CITY OF PORTLAND, MAINE

This is to certify that COYNE PETER TRUSTEE / Anemara Investment LLC
has permission to New 4 bedroom, 2.5 bath Contemporary Style Single Family Home with attached 2 car garage OCT 26 2:40
AT 1413 WESTBROOK ST 227 C005001

City of Portland, Maine - Building or Use Permit

Dept: Building	Status: Approved with Conditions	Reviewer: Jonathan Rioux	Approval Date: 10/12/2010
Note:	Ok to Issue: <input checked="" type="checkbox"/>		
<p>1) Permit approved based on the plans submitted and reviewed w/owner/contractor, with additional information as agreed on and as noted on plans.</p> <p>2) Energy Efficiency (N1101.2.1) "R-Factors of Walls, Floors, Ceilings, Building Envelope must be submitted to this Office prior to close-in or backfill.</p> <p>3) Fastener schedule per the IRC 2003</p> <p>4) The basement is NOT approved as habitable space. A code compliant 2nd means of egress must be installed in order to change the use of this space.</p> <p>5) The design load spec sheets for any engineered beam(s) / Trusses must be submitted to this office.</p> <p>6) Separate permits are required for any electrical, plumbing, sprinkler, fire alarm HVAC systems, heating appliances, in

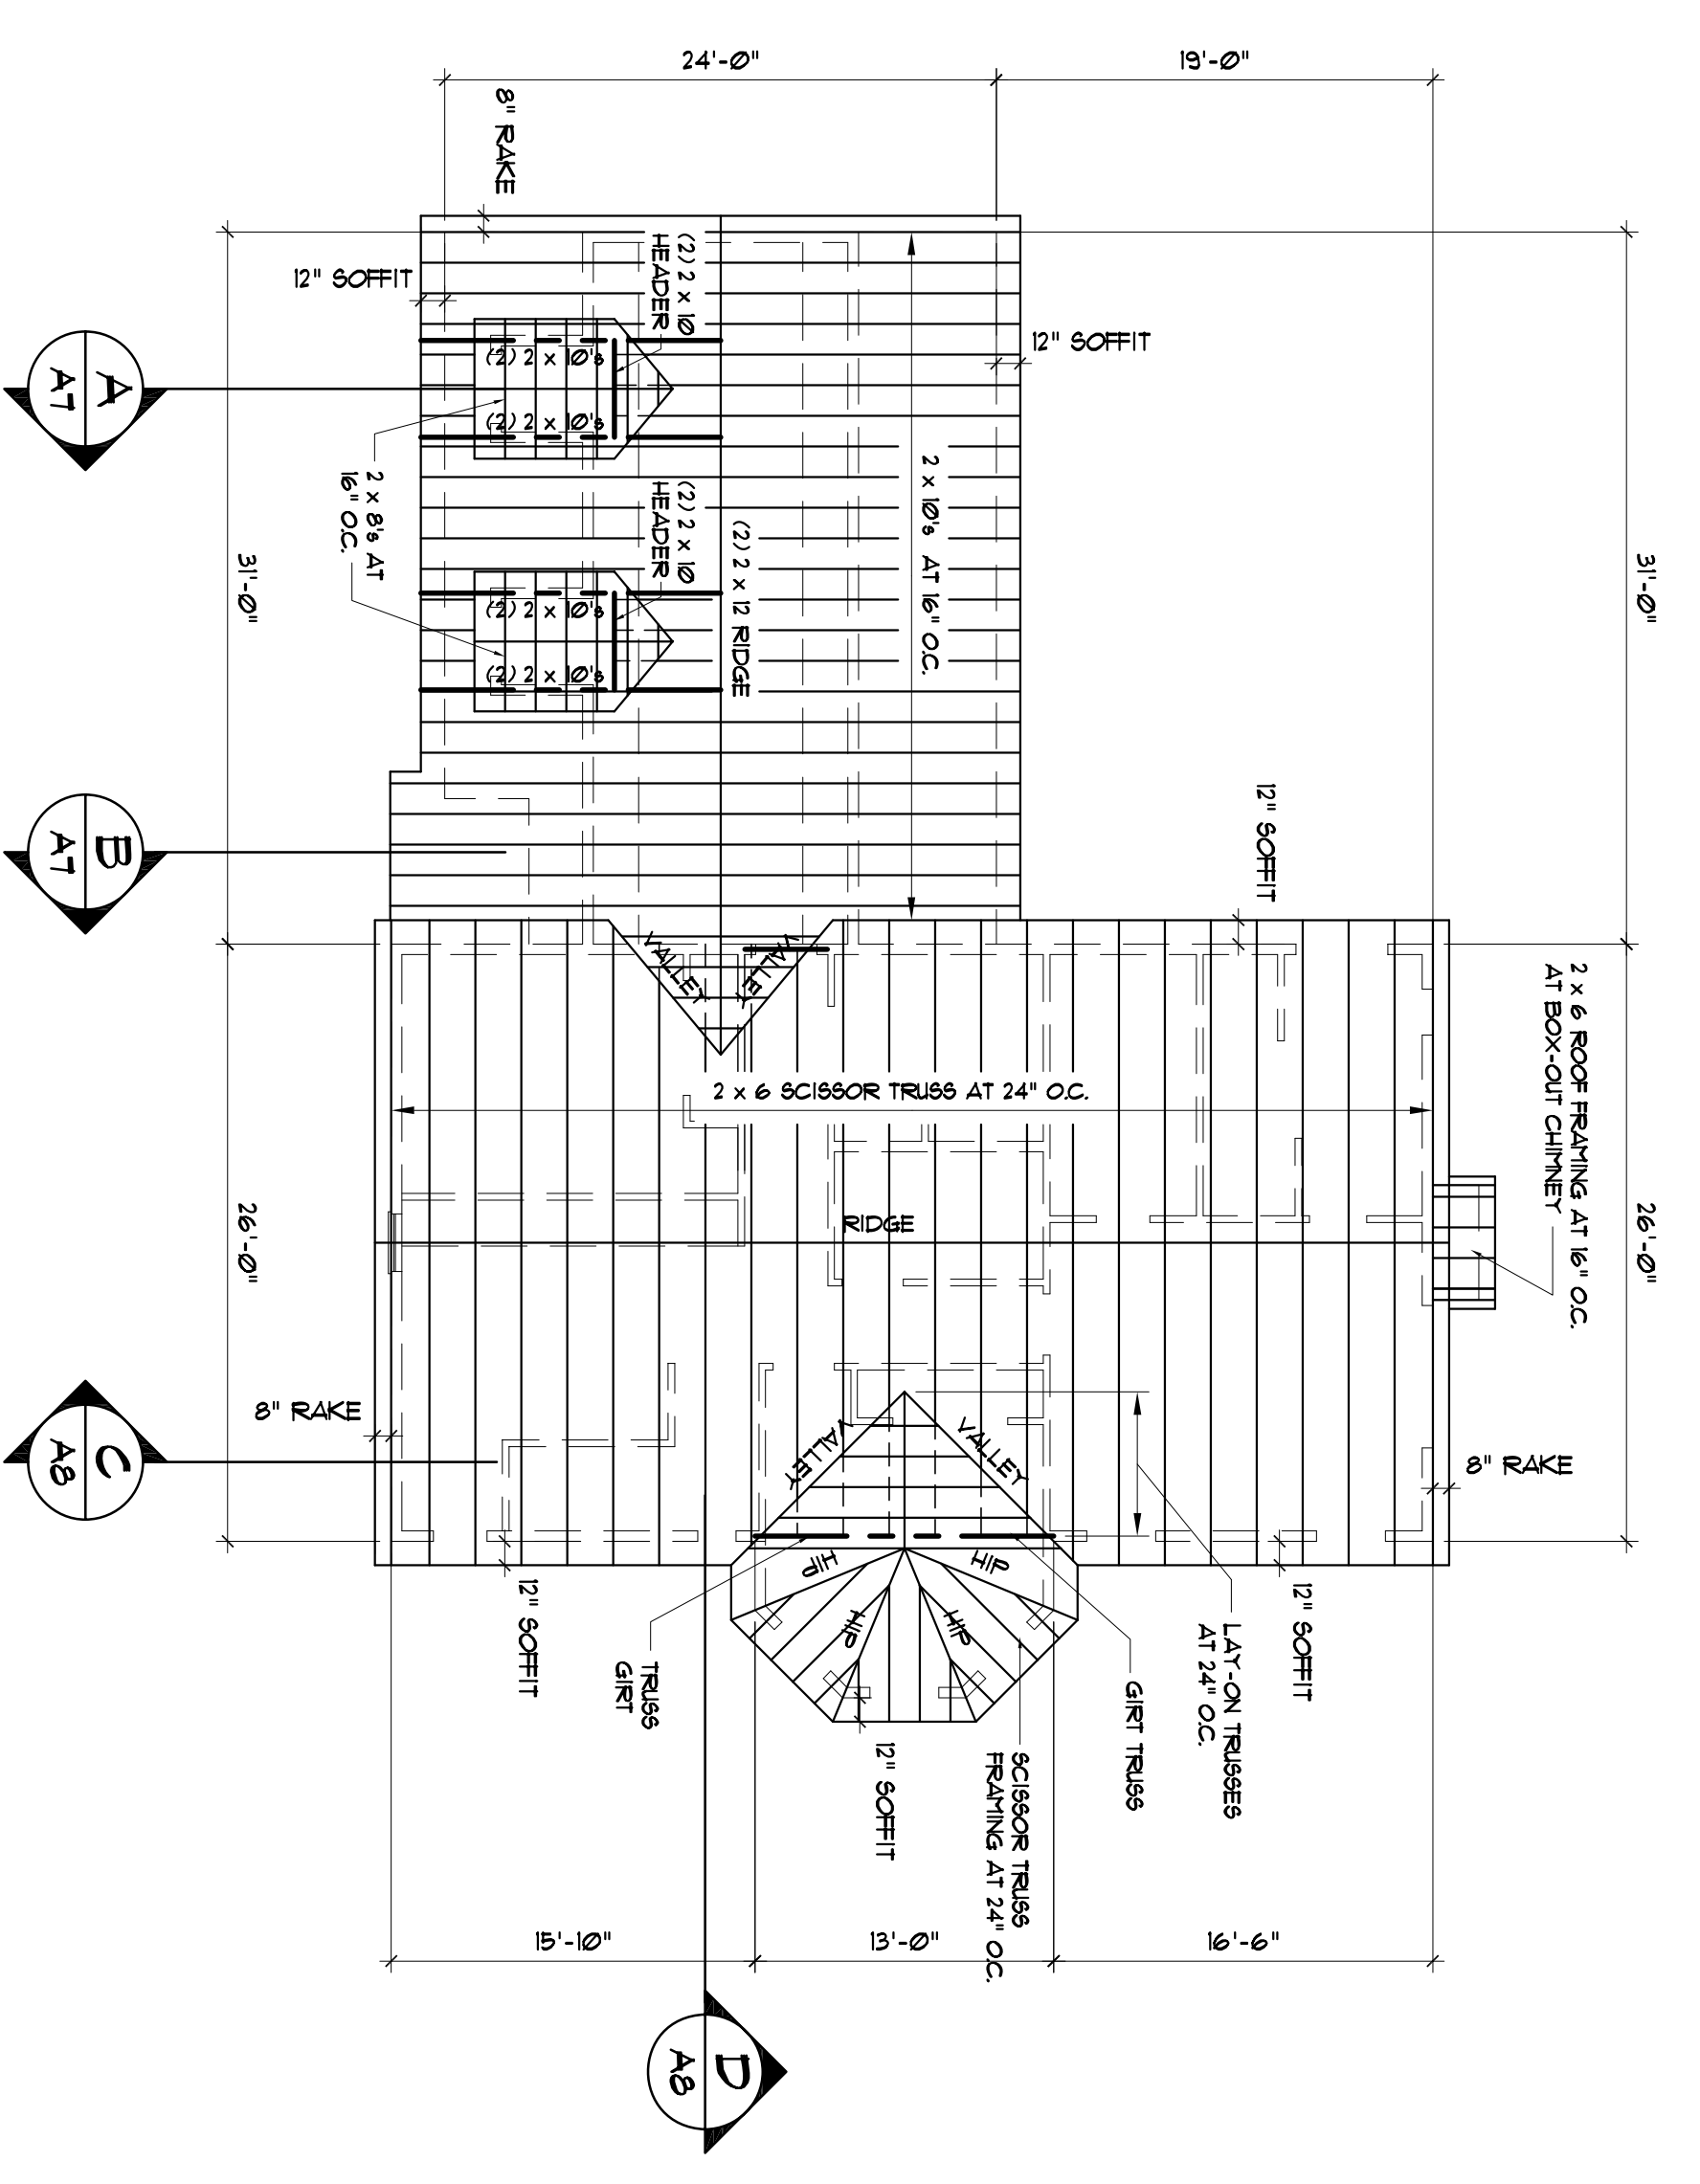
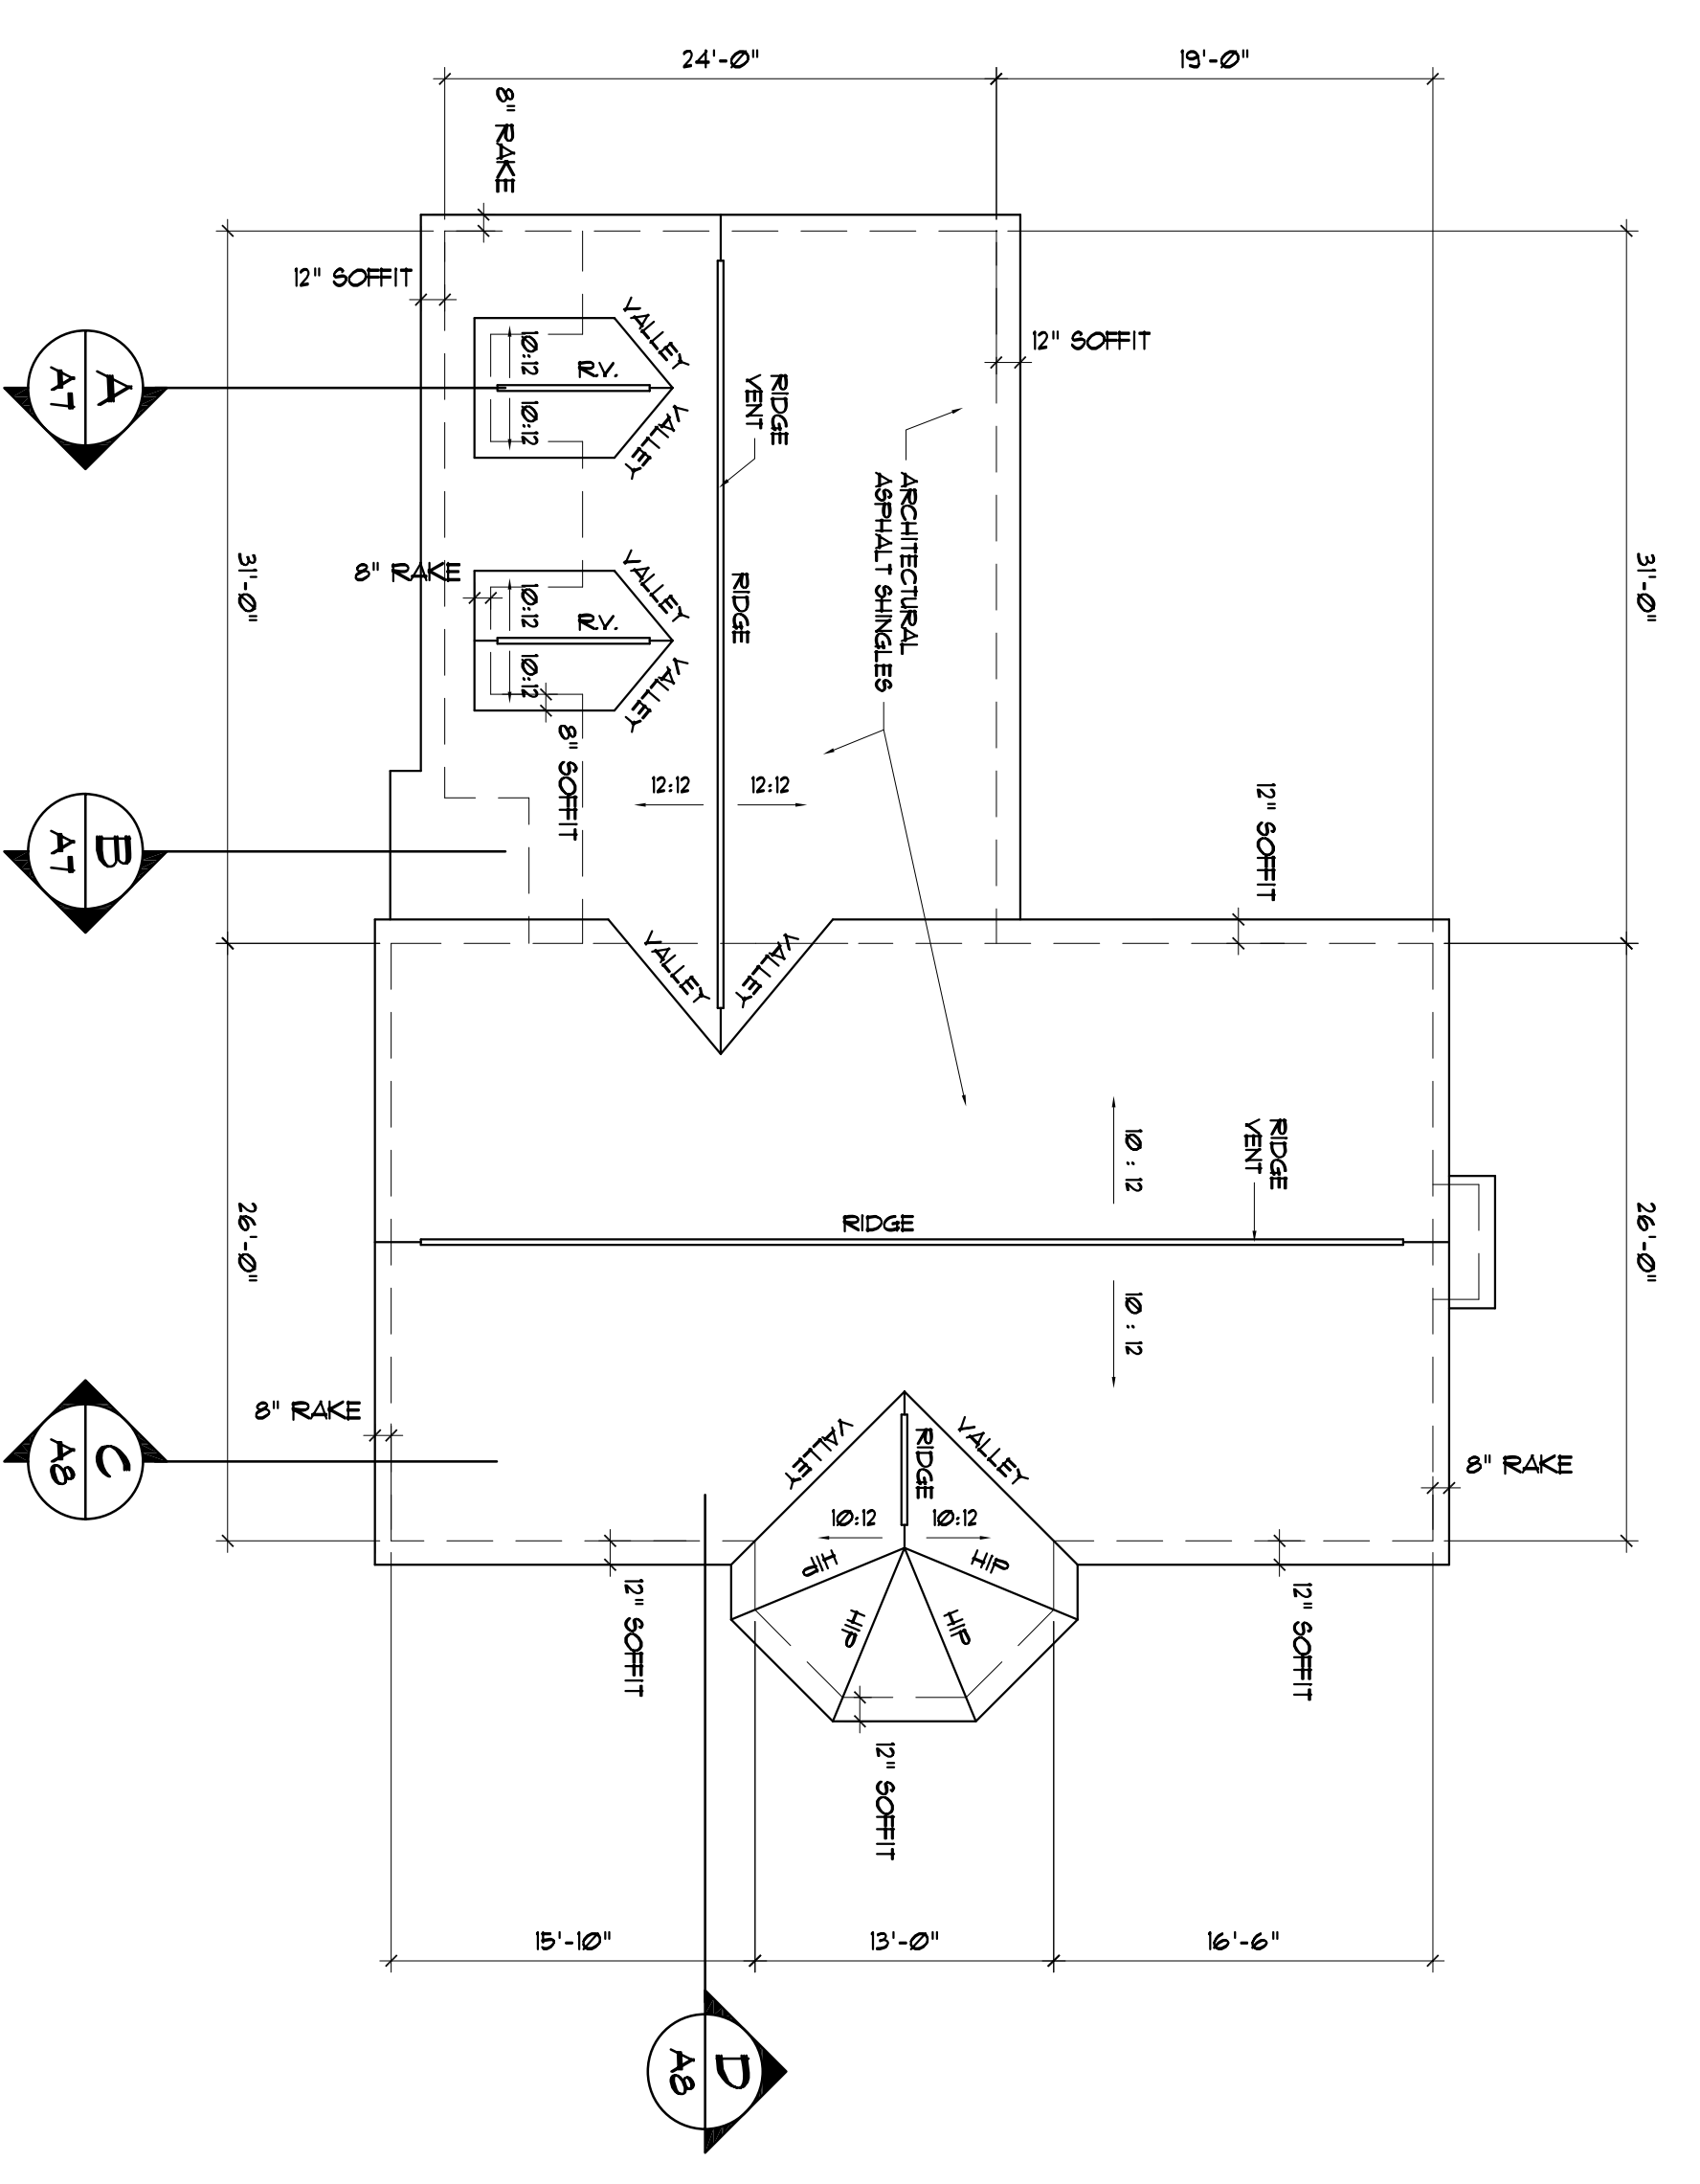
10/12/2010-jrioux: Floor joist specs: (Owner stated he will correct "dining room" flr. floor joist size/ span, plan shows increased span without bearing points): Table R602.3(1) & (2) required for fastener schedule.
